Sanctuary of Peace Residential Community at Benet Hill, PUDSP-19-2

Please accept the following comments from El Paso County Public Health (EPCPH) regarding the 49.58-acre, 27-commercial/residential lot development project referenced above:

285 ENGINEERING P.O. BOX 1048 CONIFER, CO 80433 (720)-515-1781	PROJECT: 2018196		TITLE: SYSTEM 1 SITE PLAN		SHEET: 4/15	
	LOCATION: 3190 BENET LANE COLORADO SPRINGS, CO 80921		DATE: 06/18/2018	REVISIONS: <div>1</div> <div>2</div> <div>3</div>		
			SCALE: SHOWN			
	CLIENT: BENET HILL MONASTERY

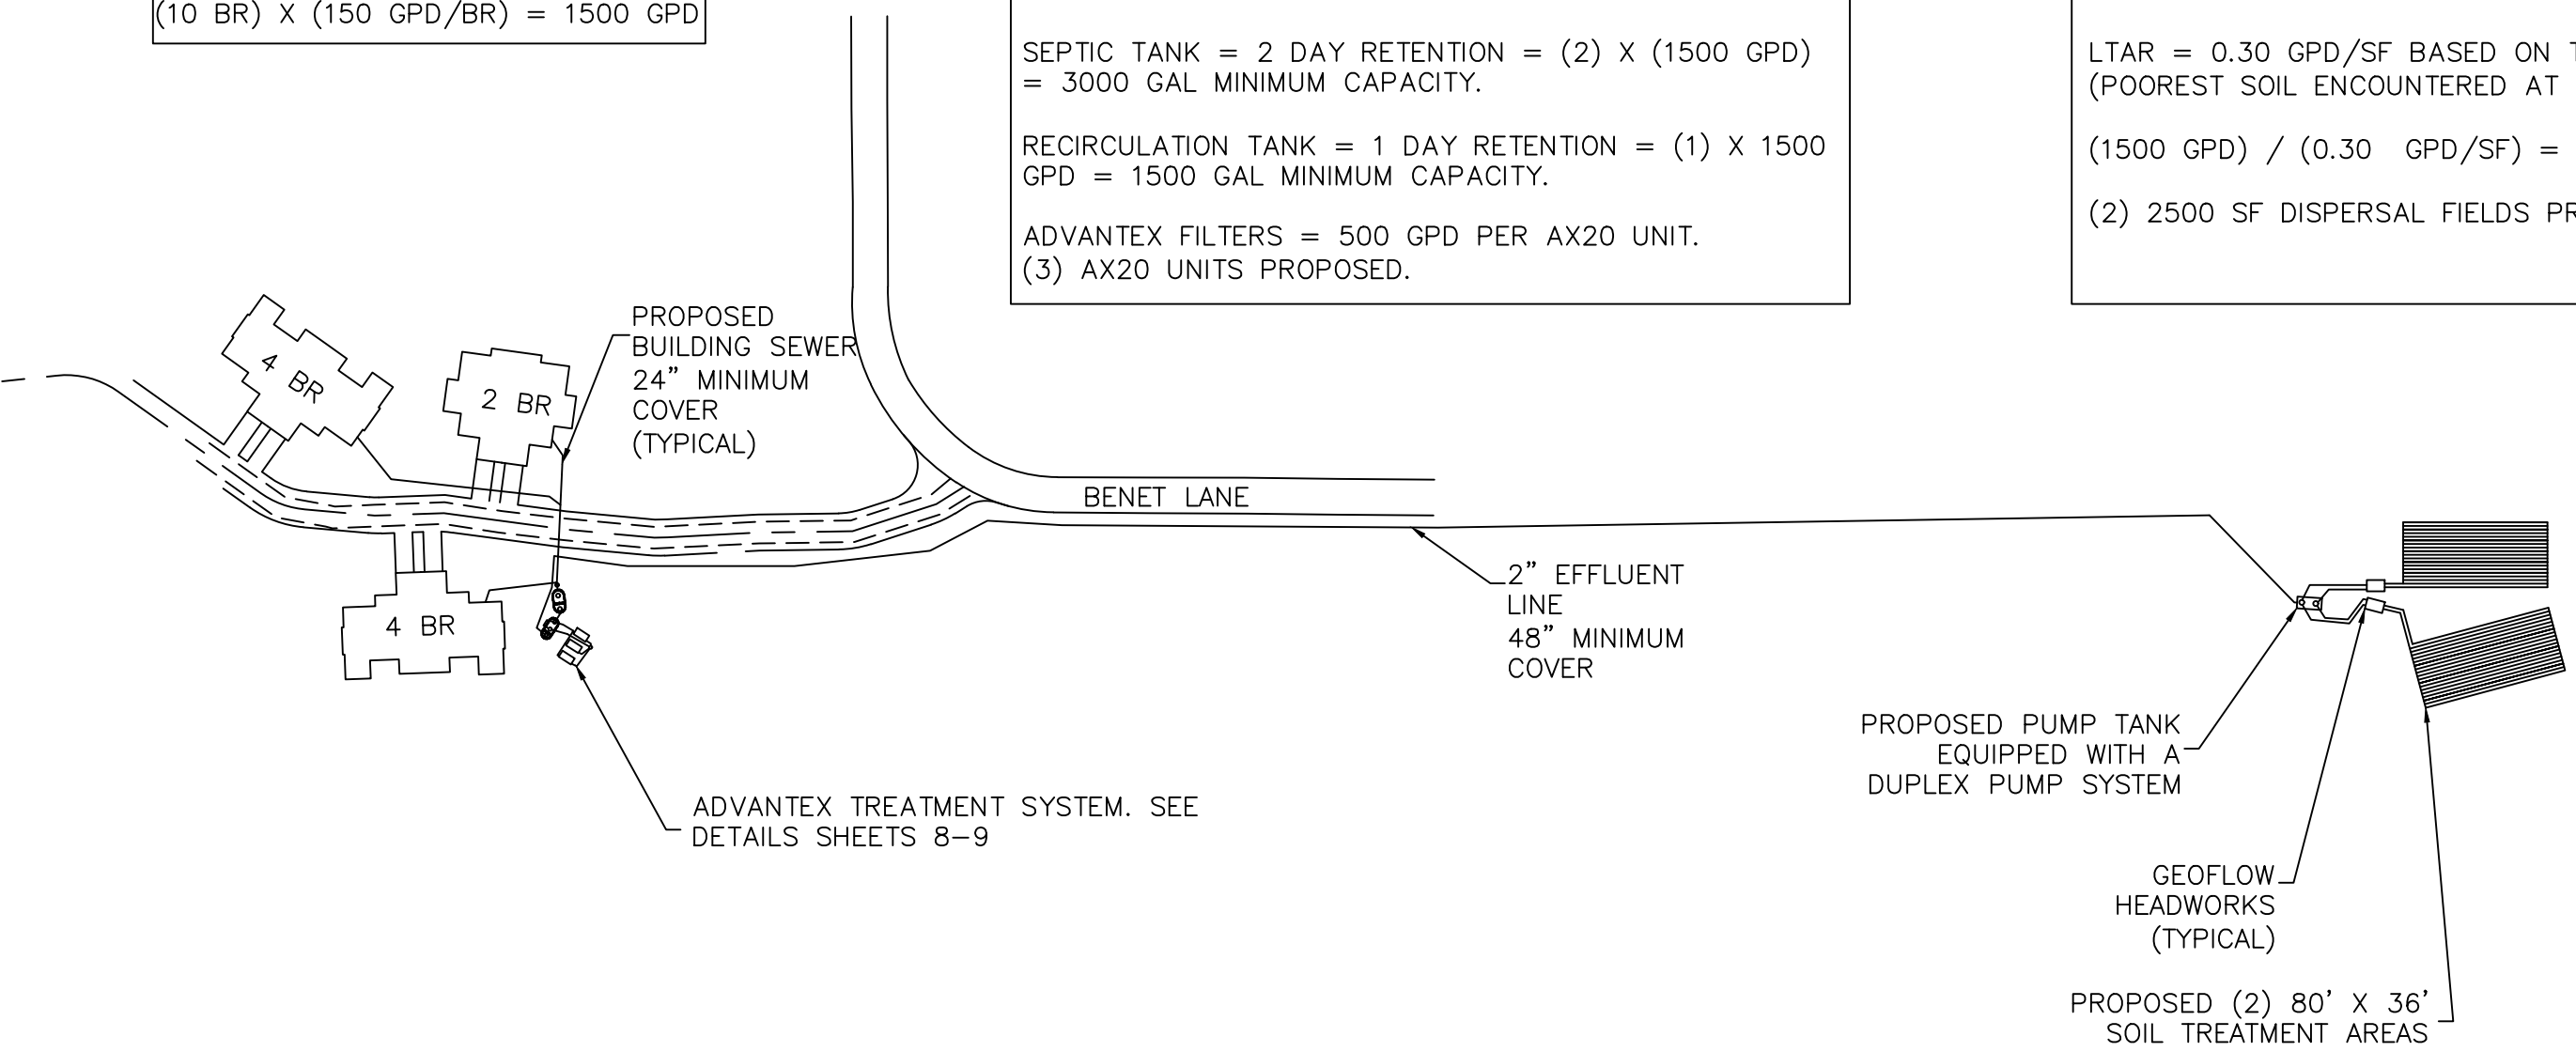
- Each of the 4 OWTS's proposed require a new OWTS Permit from El Paso County Public Health.
- Earthmoving activity in excess of one acre, but less than twenty-five acres, requires a local Construction Activity Permit from El Paso County Public Health. Go to <https://www.elpasocountyhealth.org/service/air-quality/construction-activity-application> for more information. Earthmoving activities greater than 25 acres require a Construction Activity Permit from the Colorado Department of Public Health and Environment, Air Pollution Control Division. Go to: <https://www.colorado.gov/pacific/cdphe/general-air-permits>

EXTENDED DETENTION SAND FILTER BASIN DETAIL (POND A1)  
SCALE: 1" = 20'

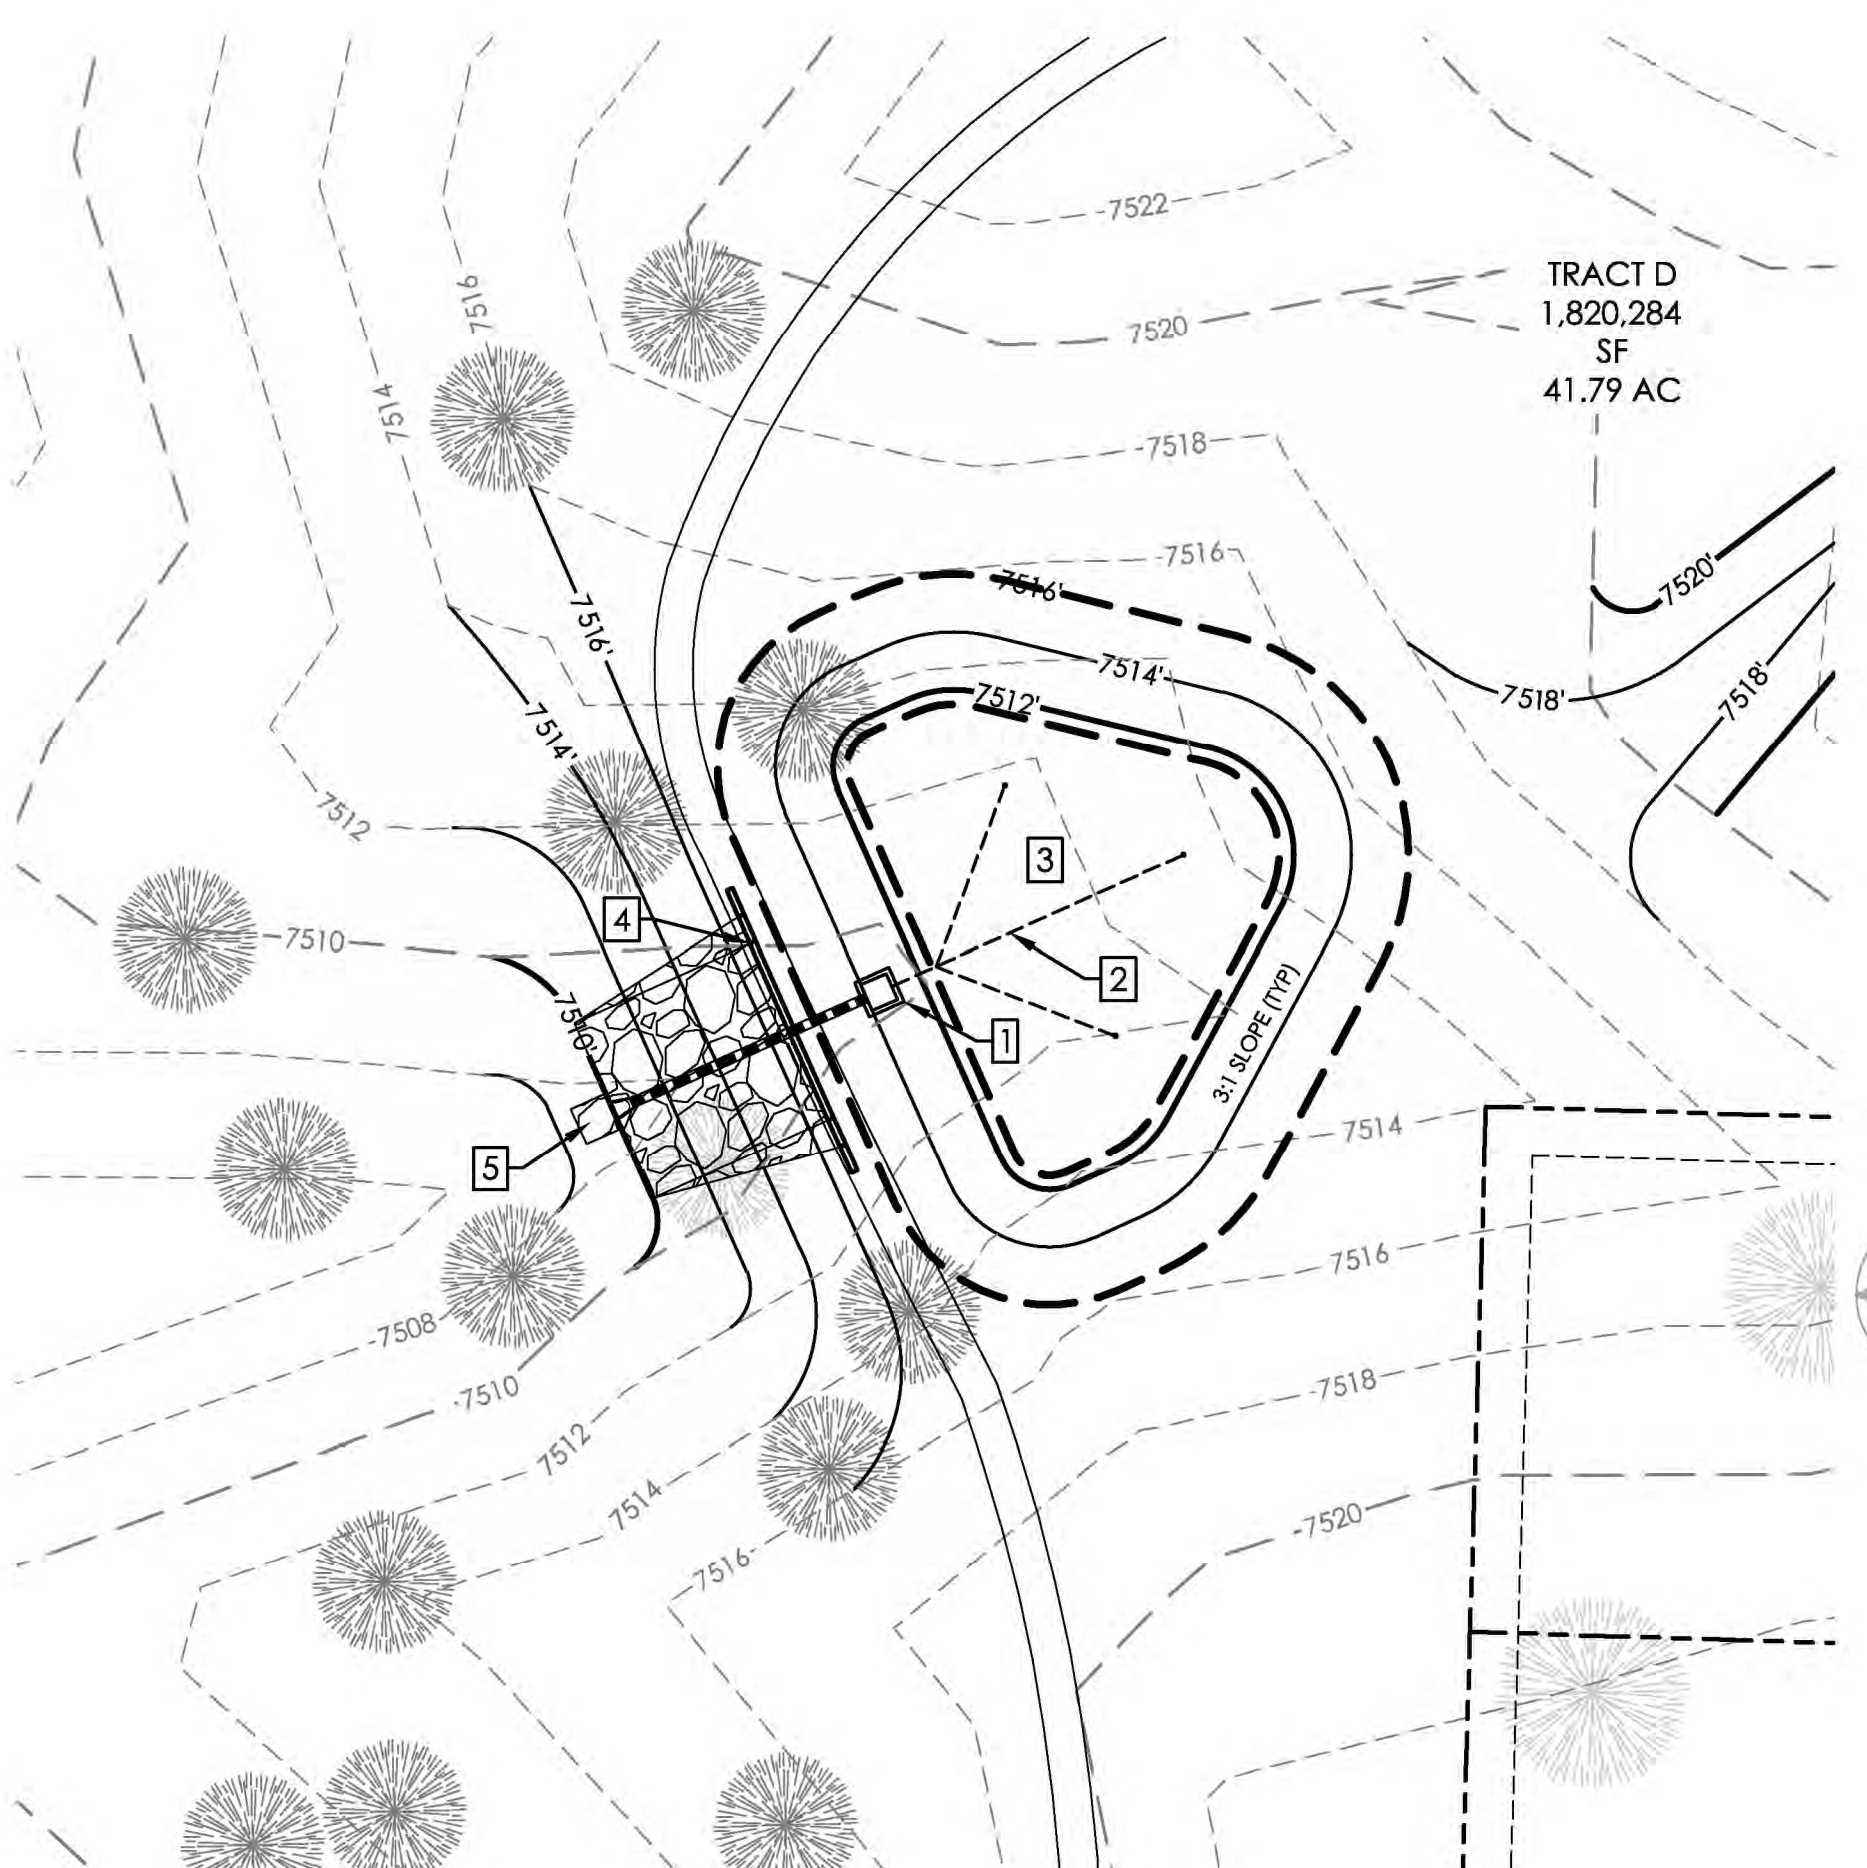
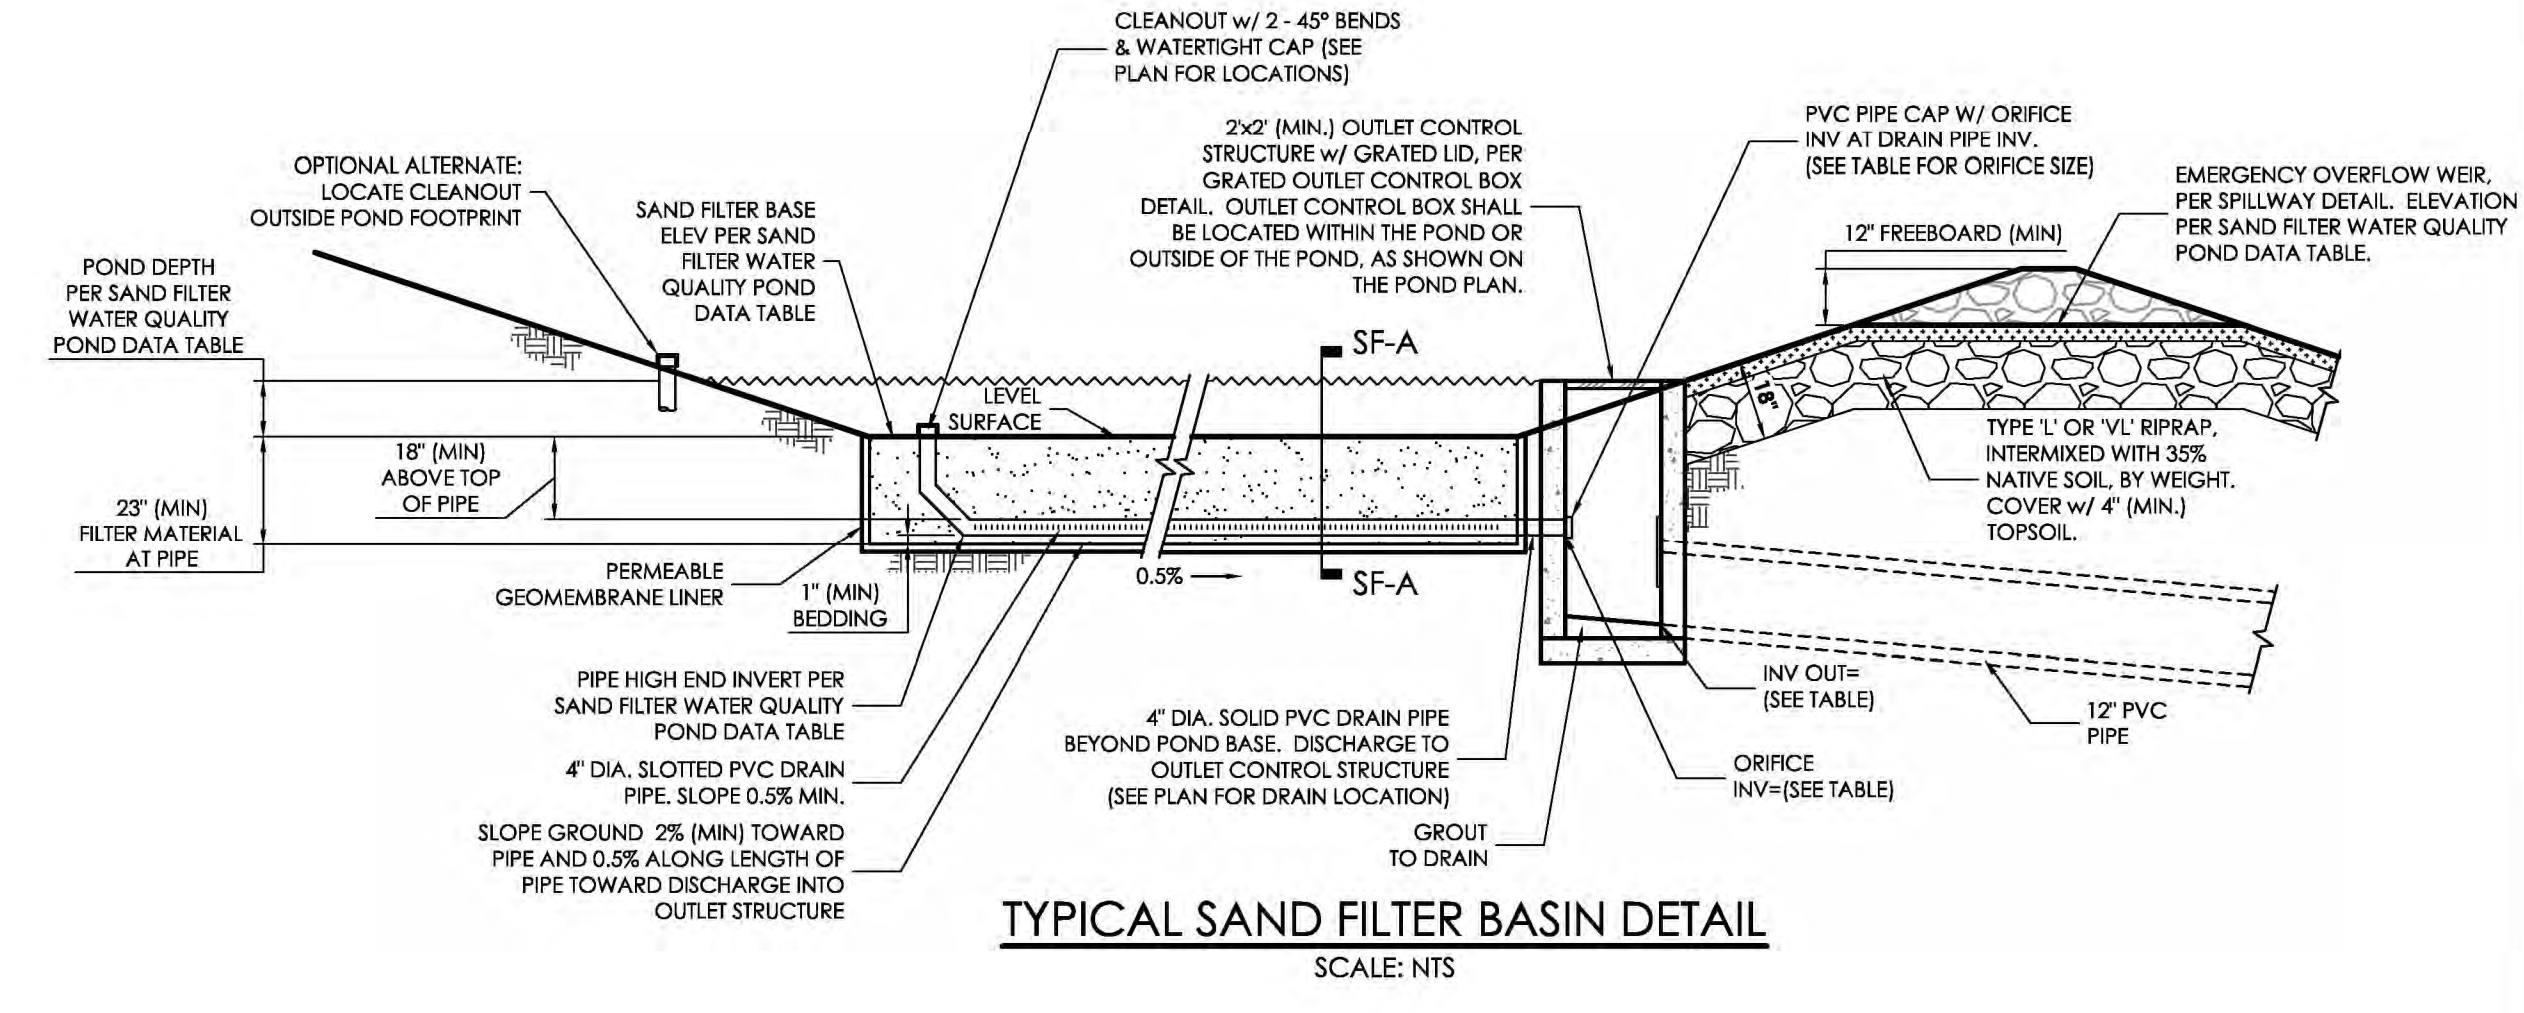
- The water quality basins must have mosquito control responsibilities included in the construction design and/or maintenance plan to help reduce mosquito breeding habitat and minimize the potential for West Nile Virus.
